APPLICANT'S RESPONSE TO ISSUES RAISED AT DEADLINE 5

Drax Bioenergy with Carbon Capture and Storage

Document Reference Number: 8.10.5

PINS Reference: EN010120

Plate 1.21 - LT4 Night-time Histogram

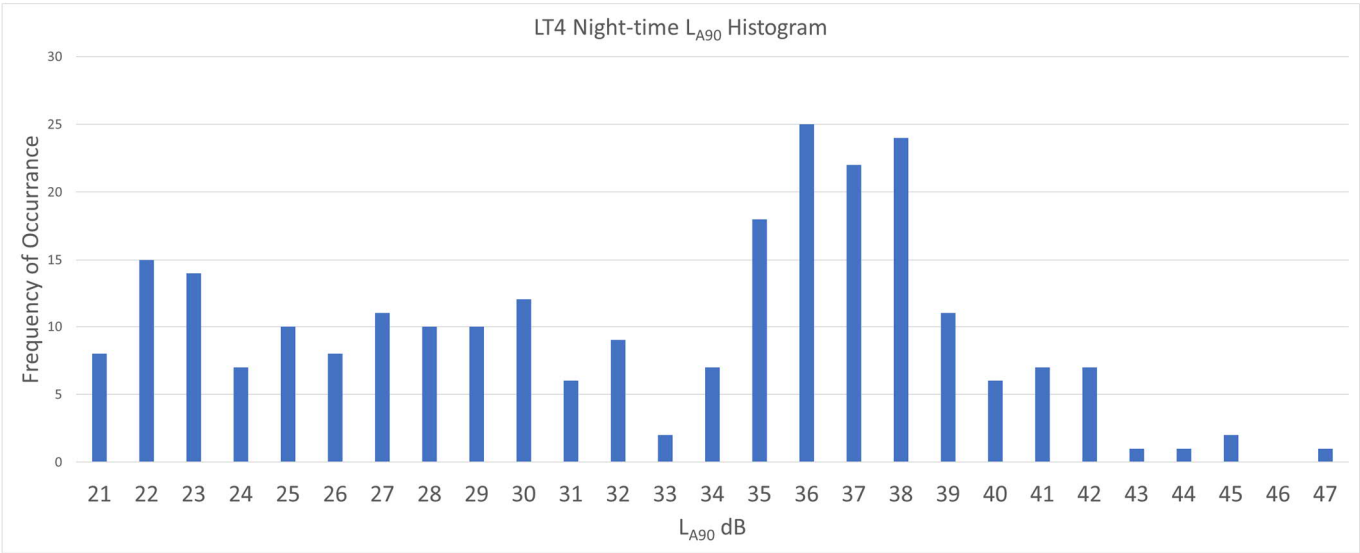
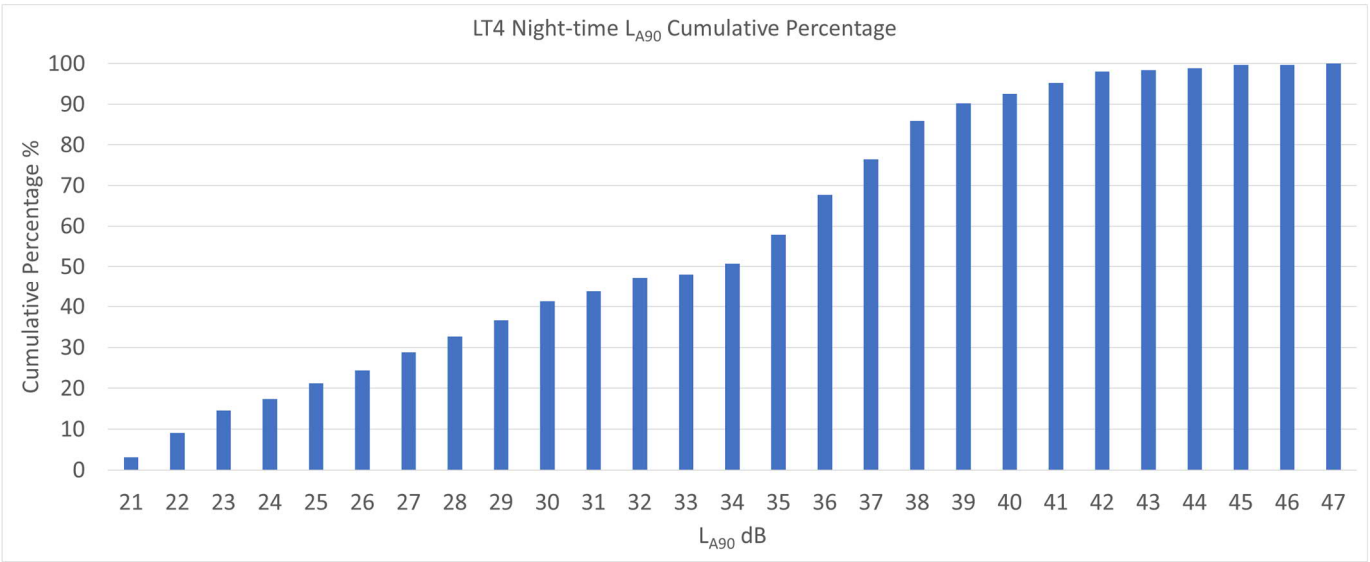
Response Ref. (location in original submission)	Comment	Applicant's Response
2.1	<p>Paragraph 7.1 - Measurement location LT4 and Receptor R14</p> <p>It was questioned whether or not LT4 monitoring location data was representative of receptor R14. LT4 monitoring location data is used to set the background noise level at R14, a distance of roughly 1.5km apart. Taking into account the low background noise level reported (28dB LA90,15min), similar distances to Drax Power Station which is likely a dominant contributor to the existing noise climate (~1km), and rural context at both locations, there are no objections to adopting LT4 monitoring location data to set the R14 background noise level.</p>	<p>The Applicant notes and agrees with this response.</p>
